ITEM 1.2 (a)

Issue/ Objection:
Solar Access

85 Harrington Street
The Rocks
GOLDEN AGE & HANNAS THE ROCKS

TITLE
RESPONSE TO DoPE
ITEM 1.2 (a)

TITLE
**Diagrams
Solar Access**

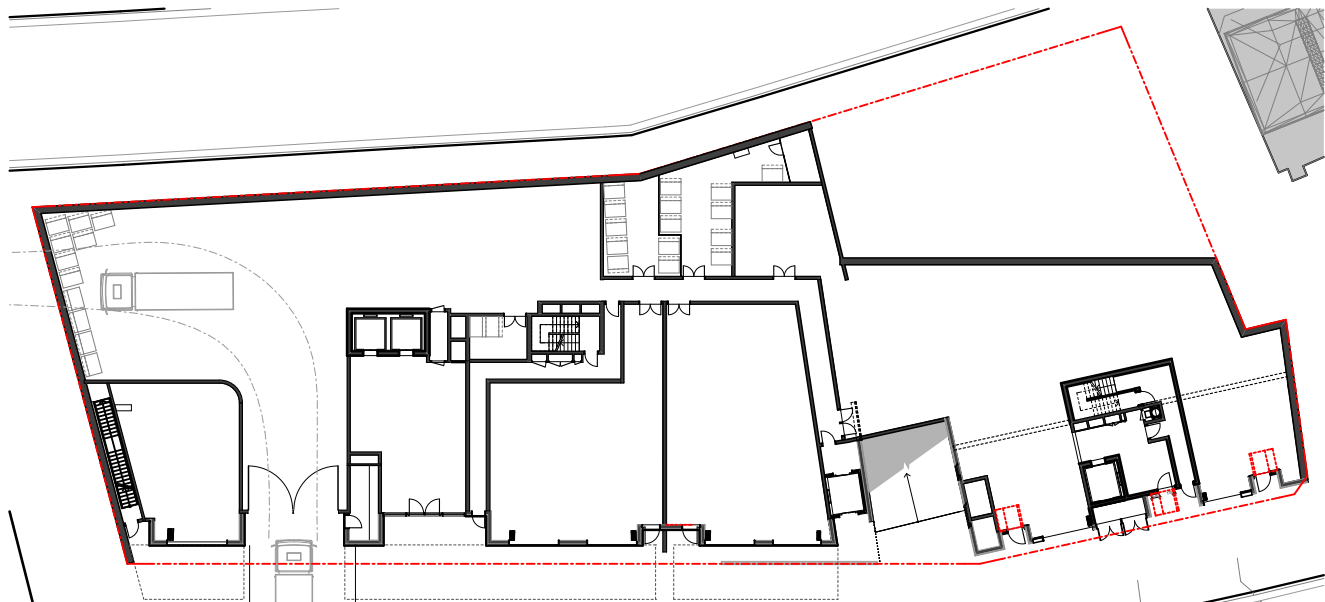
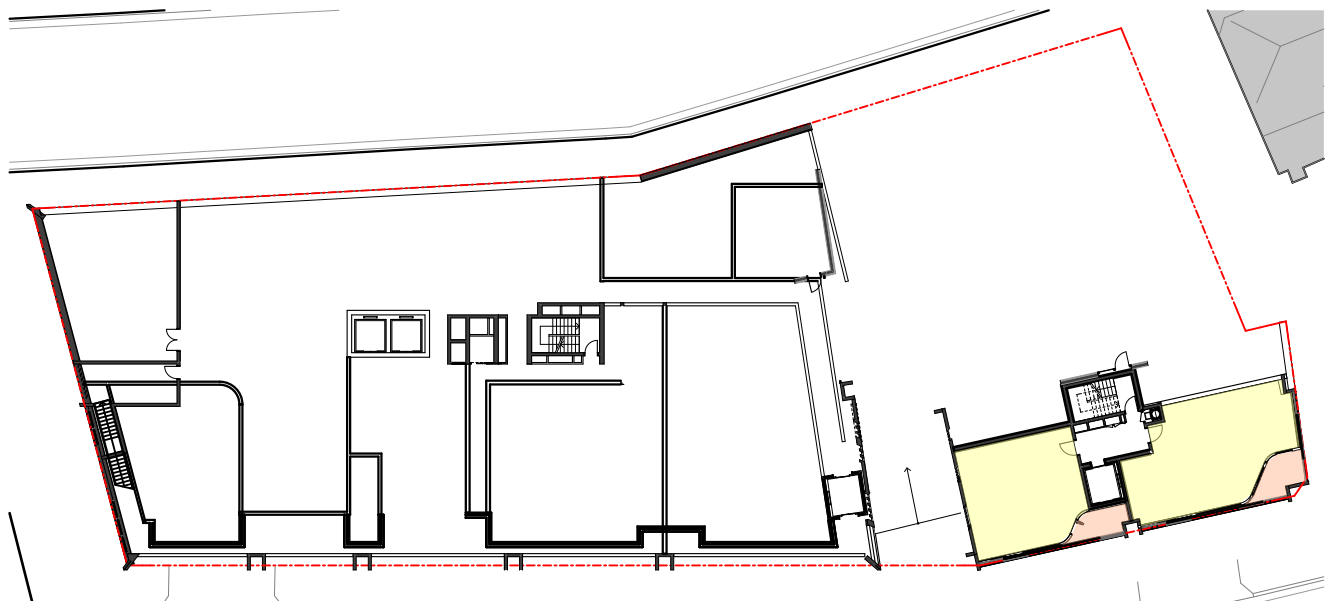
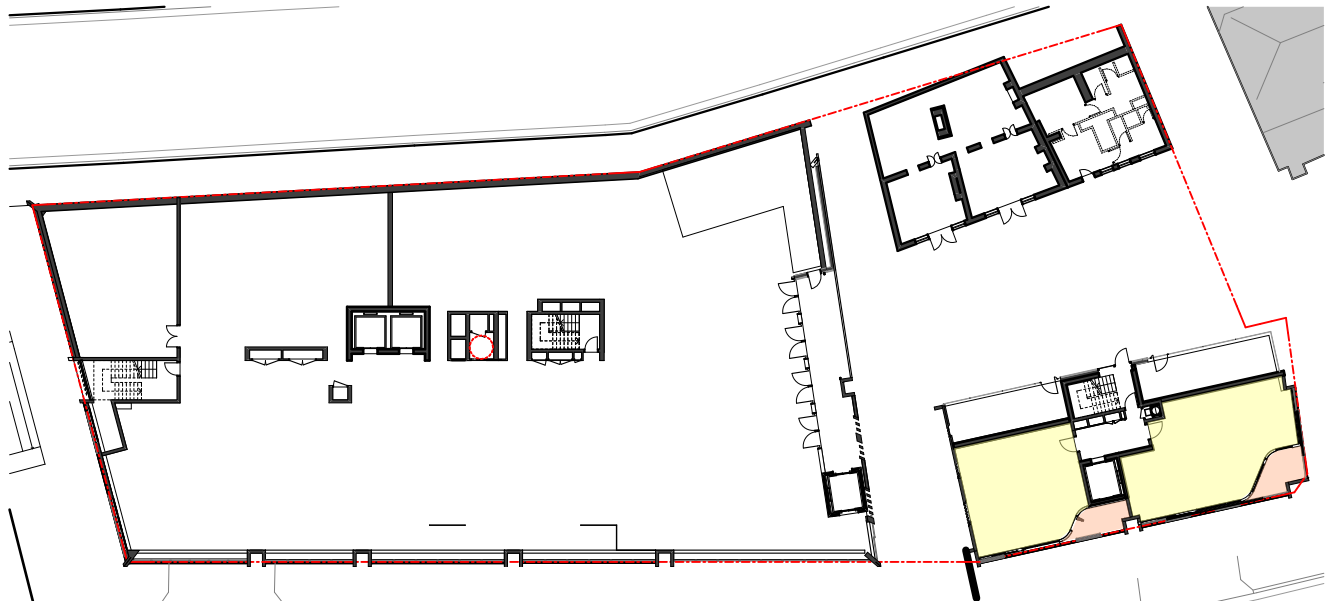
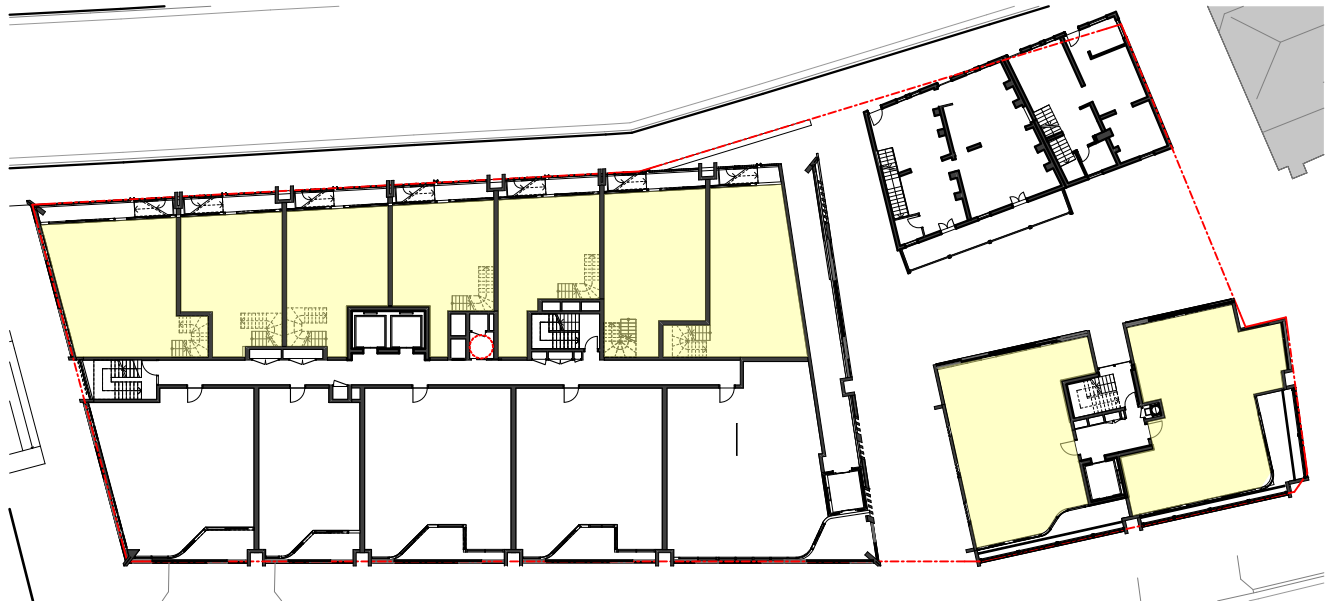
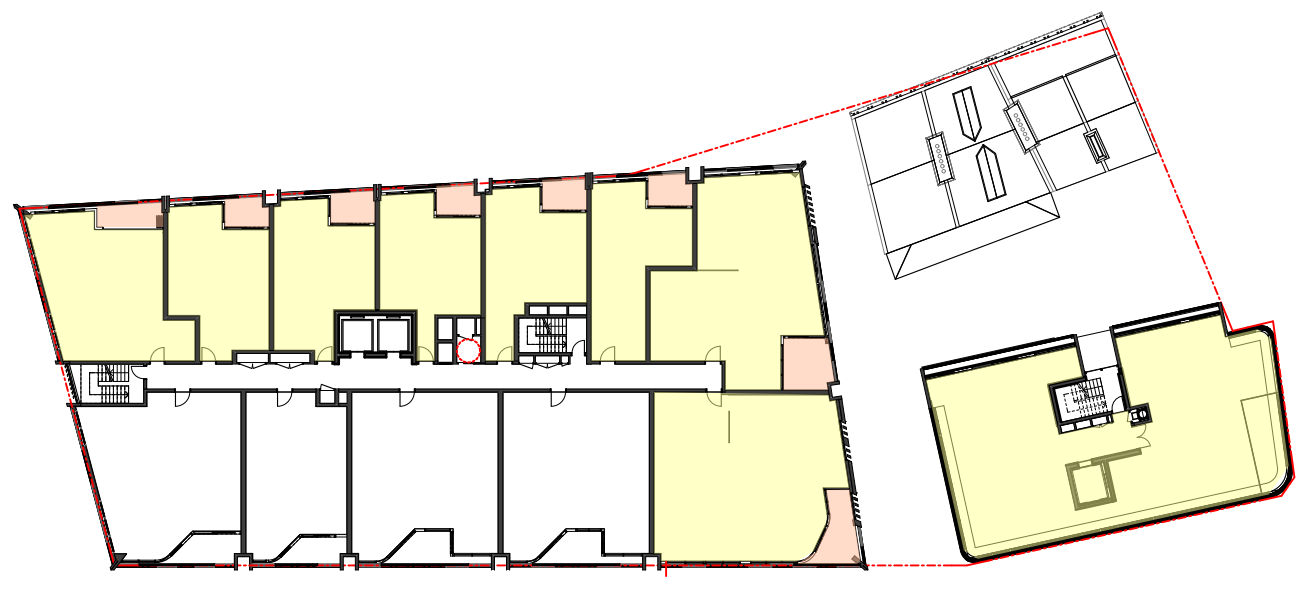
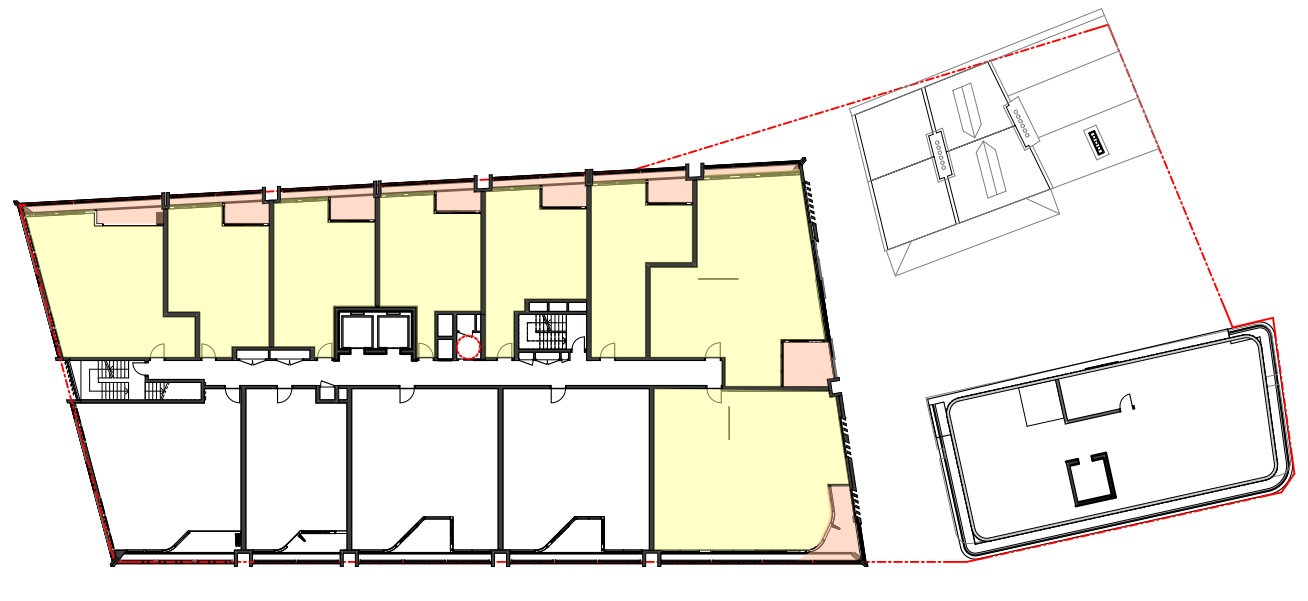
Description:
The proposal indicates 70% of units will receive at least two hours solar access in midwinter (9am to 3pm) and all units will receive at least one hour of solar access in midwinter. Please provide a solar access study demonstrating the above including consideration of the proportion/area of the living rooms and balconies receiving solar access.

Response
The site is located in a dense, urban, city setting. The topography of the site relies upon a design response resulting in a building with a North/South orientation. As such all apartments face an East or West direction and are afforded good solar amenity. The building results in **no single aspect south facing apartments**. An extensive solar access study has been undertaken to show that 70% of units will receive at least 2 hours solar access in midwinter (9am to 3pm).
